Pear tree Hill Solar Farm

Environmental Statement Addendum

Revision **45** (tracked)

Application Document Ref: EN010157/APP/8.2

Figure 1.2: Land Areas and Cable Routes Plan with Field Numbering System

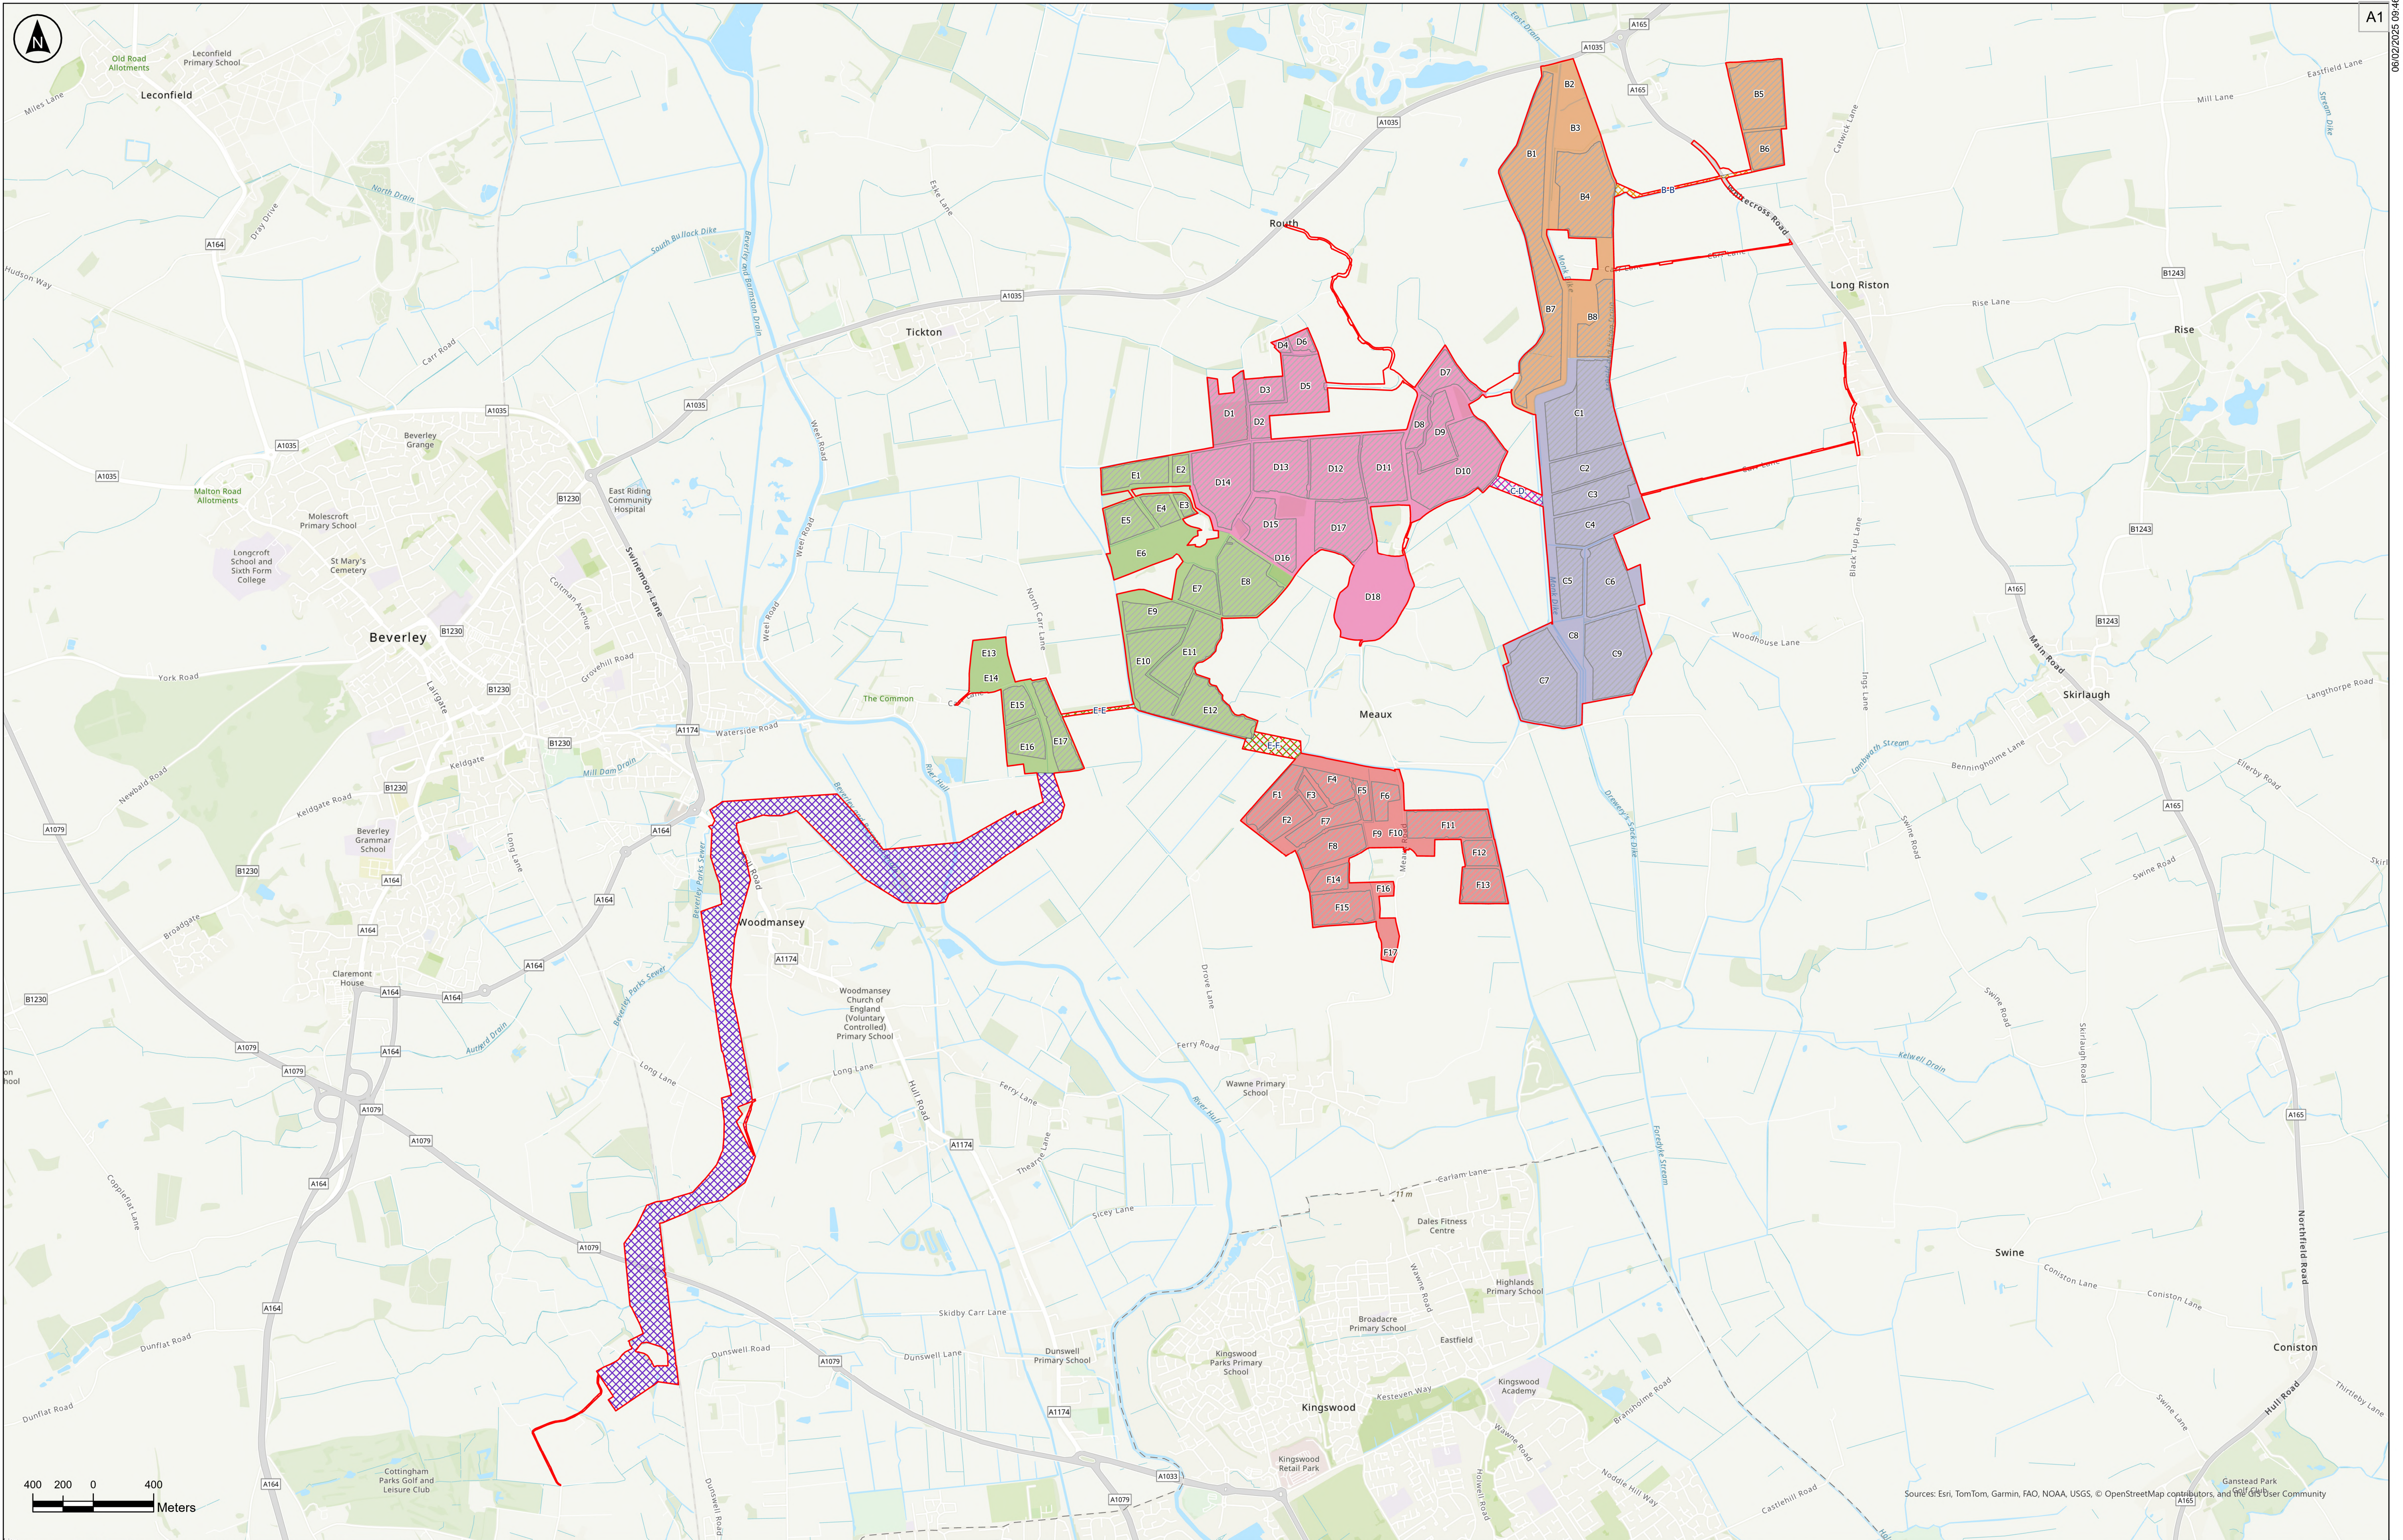
Document reference	Reason for amendment	ES Amendment July 2025
	Figure 1.2 also requires amendment to reflect the removal of plots 10-4, 10-5 and 10-6 as part of change/correction 2.	
ES Volume 3, Figure 2.1: Environmental Features Plan [APP-054]	Figure 2.1 requires amendment to reflect the removal of plots 10-4, 10-5 and 10-6 as part of change/correction 2.	
ES Volume 3, Figure 3.1: Indicative Operational Layout Plan [APP-055]	Figure 3.1 requires amendment to reflect the removal of a section of solar array from Land Area B as part of change/correction 1. Figure 3.1 also requires amendment to reflect the removal of plots 10-4, 10-5 and 10-6 as part of change/correction 2.	
ES Volume 3, Figure 3.2: Heights Parameters Zonal Plan [APP-056]	Figure 3.2 requires amendment to reflect the removal of a section of solar array from Land Area B as part of change/correction 1. Figure 3.2 also requires amendment to reflect the removal of plots 10-4, 10-5 and 10-6 as part of change/correction 2.

Document reference	Reason for amendment	ES Amendment September 2025
		Resubmitted on 10 September 2025 as: ES Volume 3, Figure 1.2: Land Areas and Cable Routes Plan with Field Numbering System – Rev 2
ES Volume 3, Figure 2.1: Environmental Features Plan [REP1-019 and REP1-020]	All changes to the DCO Application (excluding change 7) have meant that an update to the Order Limits is required. For change 9, sheet 2a has been added.	Figure 2.1 is amended to show the proposed Order Limits following the change application in respect of changes 3, 4, 5, 6, 8 and 9. Resubmitted on 10 September 2025 as: ES Volume 3, Figure 2.1: Environmental Features Plan – Rev 3
ES Volume 3, Figure 3.1: Indicative Operational Layout Plan [APP-055]	All changes to the DCO Application (excluding change 7) have meant that an update to the Order Limits is required. Change 7: Amendments required to show the updated layout.	Figure 3.1 is amended to show the proposed Order Limits following the change application in respect of changes 3, 4, 5, 6, 8 and 9. New layout shown for Change 7. Resubmitted on 10 September 2025 as: ES Volume 3, Figure 3.1: Indicative Operational Layout Plan – Rev 2

Figure 14.3: Public Rights of Way and Long Distance Paths Within and Adjacent to the Proposed Development

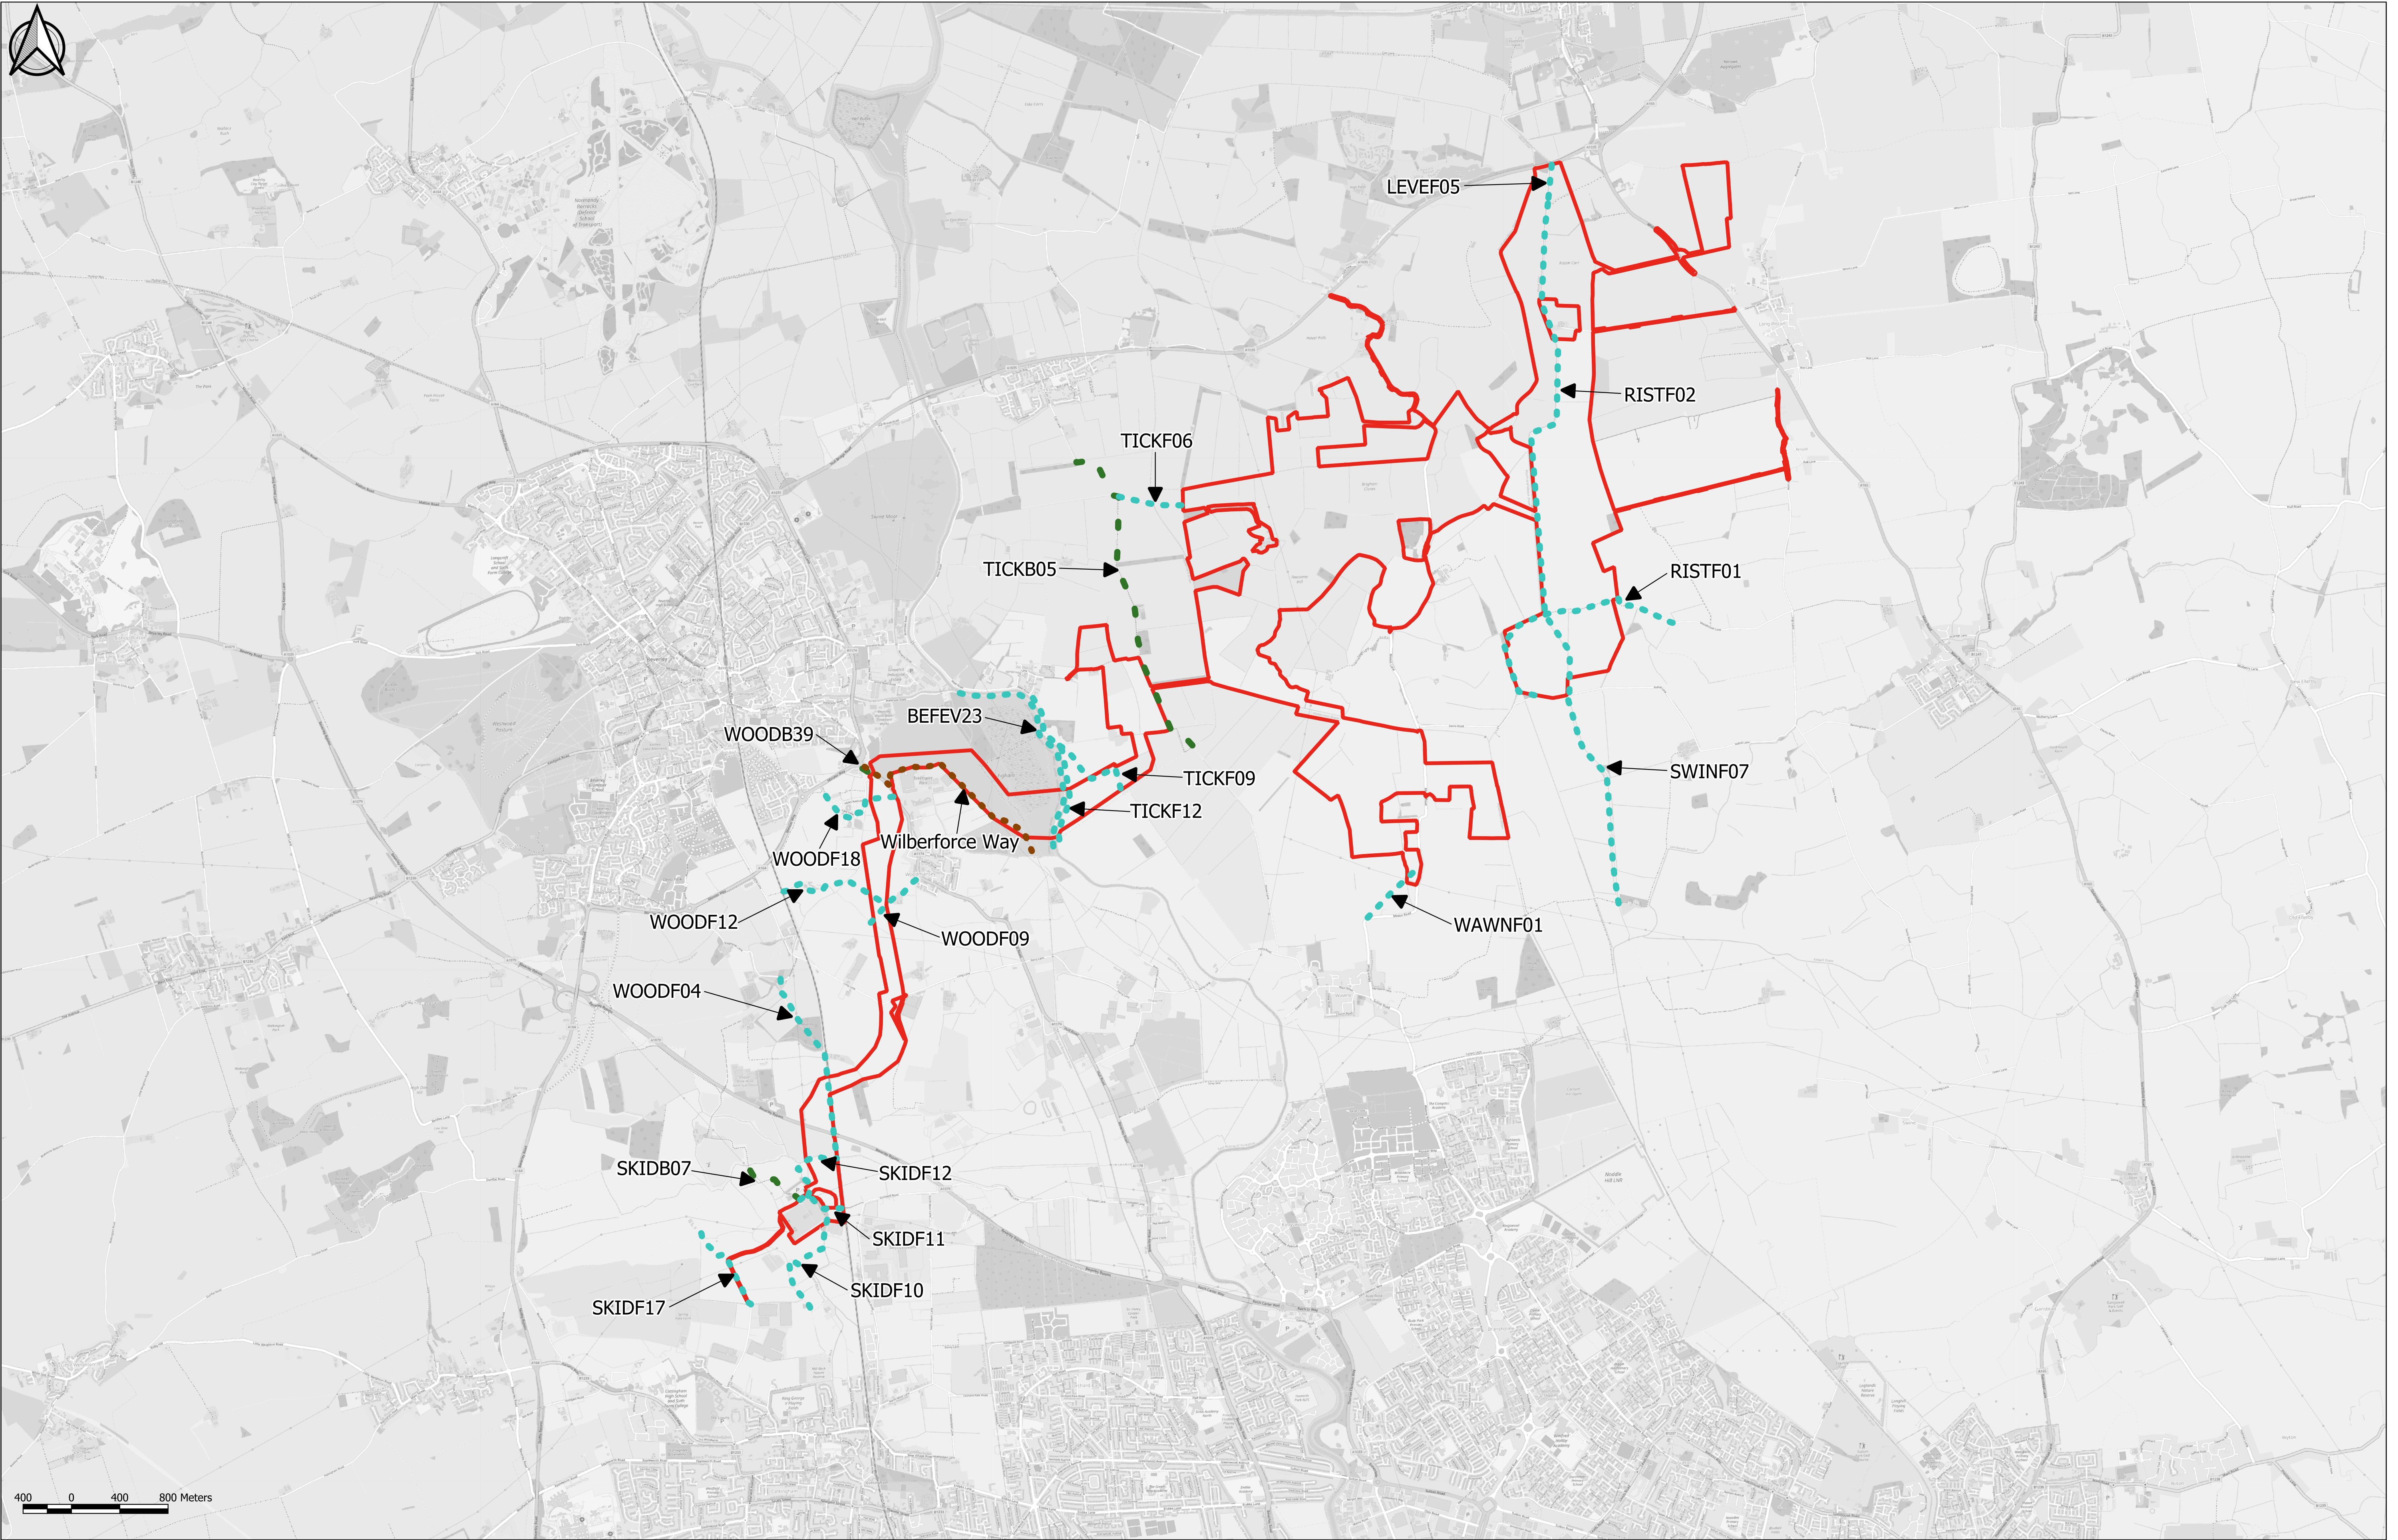
Document reference	Reason for amendment	ES Amendment July 2025
ES Volume 3, Figure 14.3: Public Rights of Way and Long Distance Paths Within and Adjacent to the Proposed Development [APP-091]	Figure 14.3 requires amendment to reflect the removal of plots 10-4, 10-5 and 10-6 as part of change/correction 2.	
ES Volume 3, Figure 14.4: Link Sensitivity [APP-092]	Figure 14.4 requires amendment to reflect the removal of plots 10-4, 10-5 and 10-6 as part of change/correction 2.	
ES Volume 3, Figure 15.1: Other Existing and/or Approved Development [APP-093]	Figure 15.1 requires amendment to reflect the removal of plots 10-4, 10-5 and 10-6 as part of change/correction 2.
